CITY OF ALBUQUERQUE

August 22, 2012

**Re: Atrisco Apartments, 1720 Atrisco Dr NW, Traffic Circulation Layout
Architect's Stamp dated 06-26-12 (H11-D068)**

Traffic Circulation Layout Plan

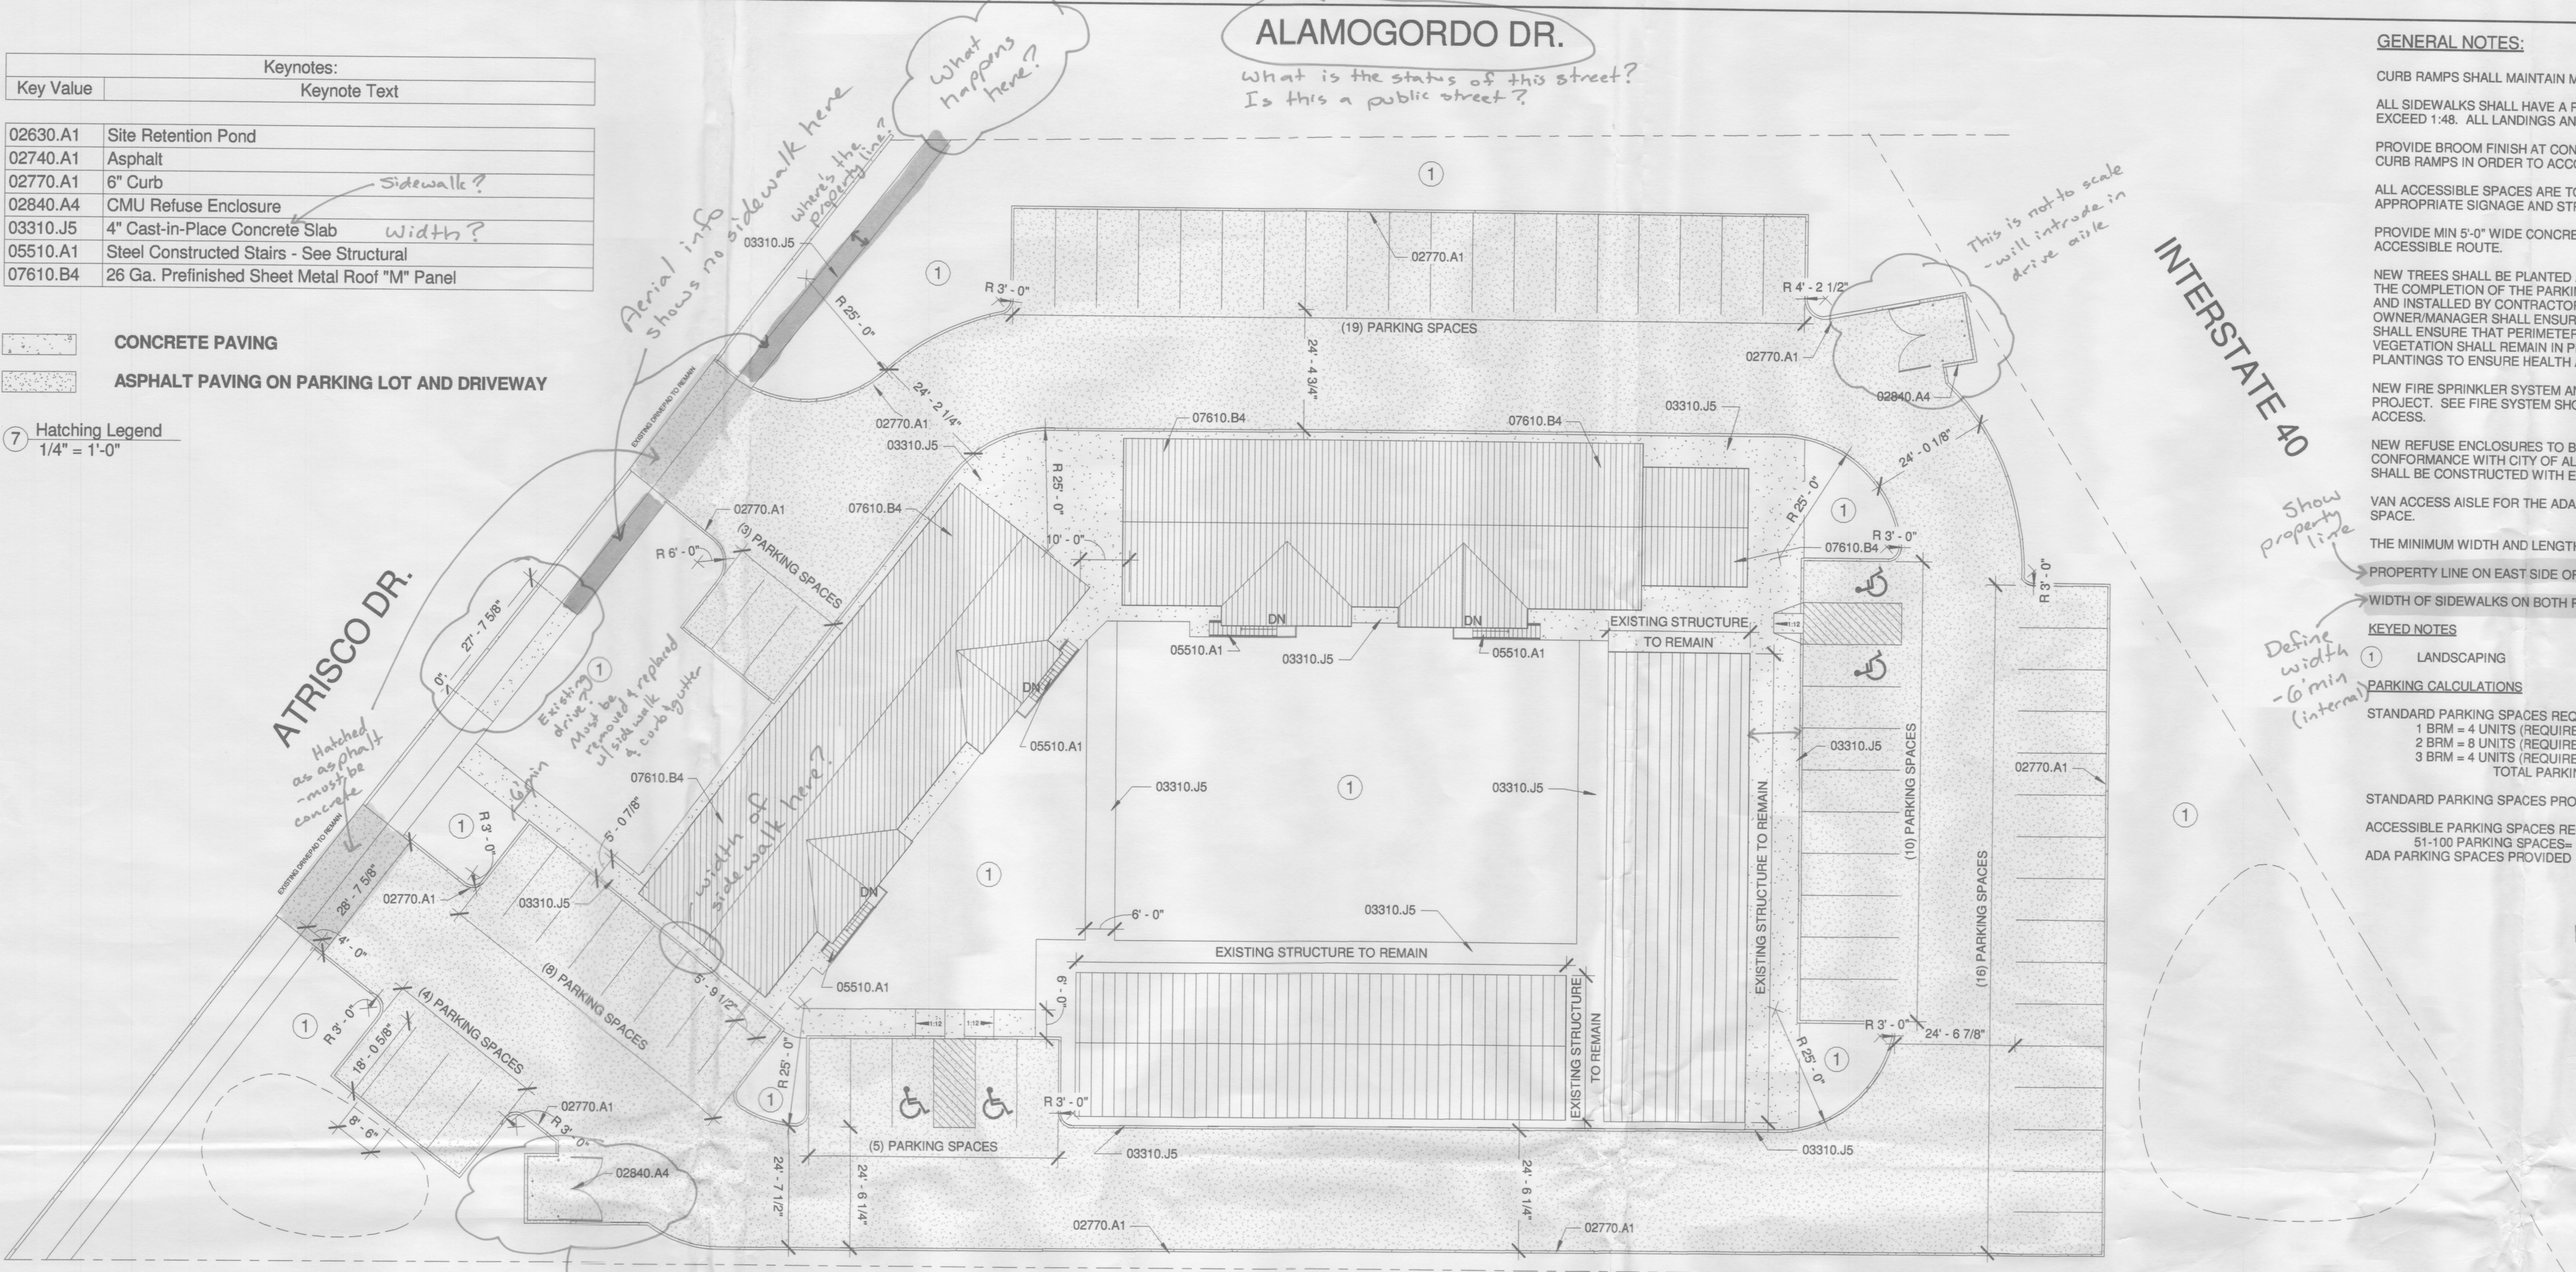
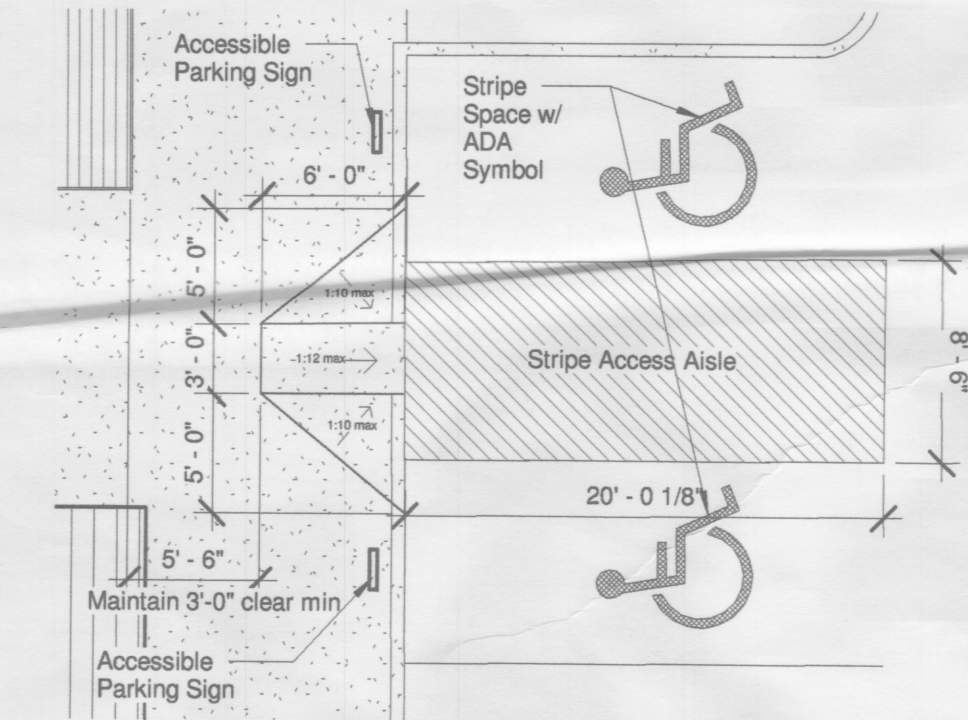
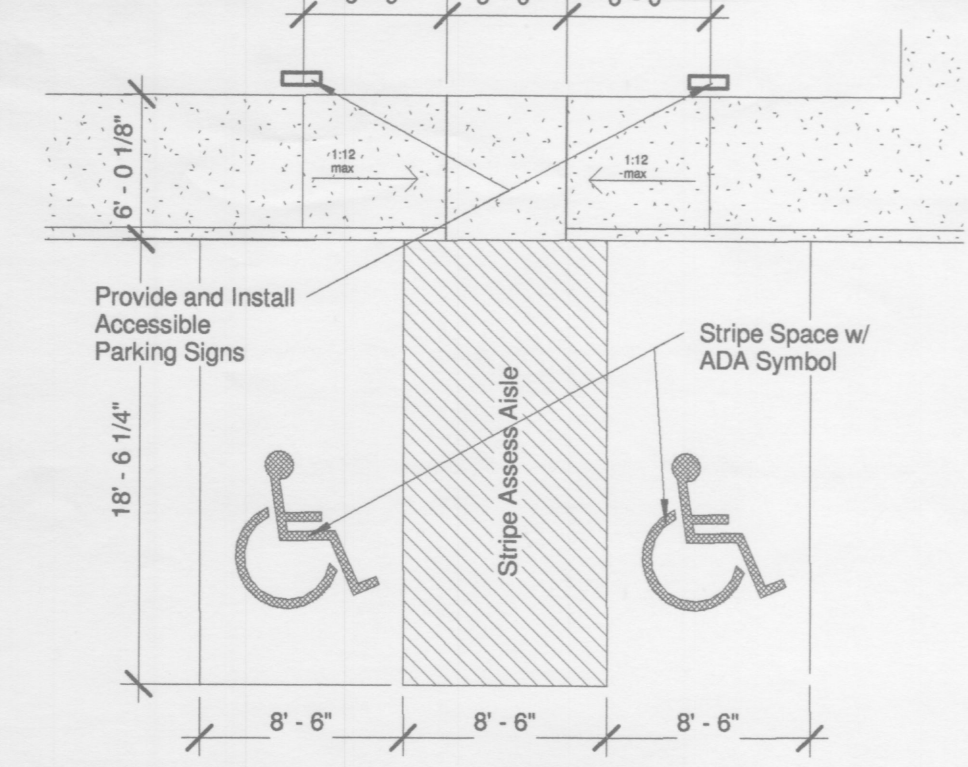
1. A north arrow must be shown on the plan.
2. Please show a vicinity map.
3. Provide the legal description on the plan.
4. Clearly show existing versus proposed conditions.

5. Recent GIS information indicates that this site consists of 5 lots. Show all lot lines on the plan. Will this site be replatted? If not, cross access easements are required.

6. The entire lot must be shown on the plan.
7. Define the width of all sidewalk, both proposed and existing.
8. List radii for all curves shown; for passenger vehicles, the minimum end island radius is 15 feet.

9. The end of aisle islands appear to provide insufficient length for the adjacent parking stalls. Please refer to Figure 23.7.2, *End of Aisle Islands*, from the *Development Process Manual* for reference.

10. Please list the width and length for all parking spaces.
11. Per the *Development Process Manual*, Chapter 23, Section 6, Part B.17, "Any drivepads that are abandoned must be replaced with sidewalk, curb and gutter by the property owner."

12. Show all ramps and provide details.
13. List the number of parking spaces required by the zoning code as well as the proposed number of parking spaces.

14. Please note that the van access aisle for the ADA accessible parking does not count as a parking stall.
15. Two-directional traffic requires a minimum 24-foot wide aisle width.

16. Sidewalk must be built along the entire roadway frontage.

17. Clarify existing conditions along Alamo Drive.
18. Keyed note 02770.A1 and 03310.J5 appear to conflict.
19. Clearly show the property line along all frontage.
20. Provide a legend, defining all legends and hatching.
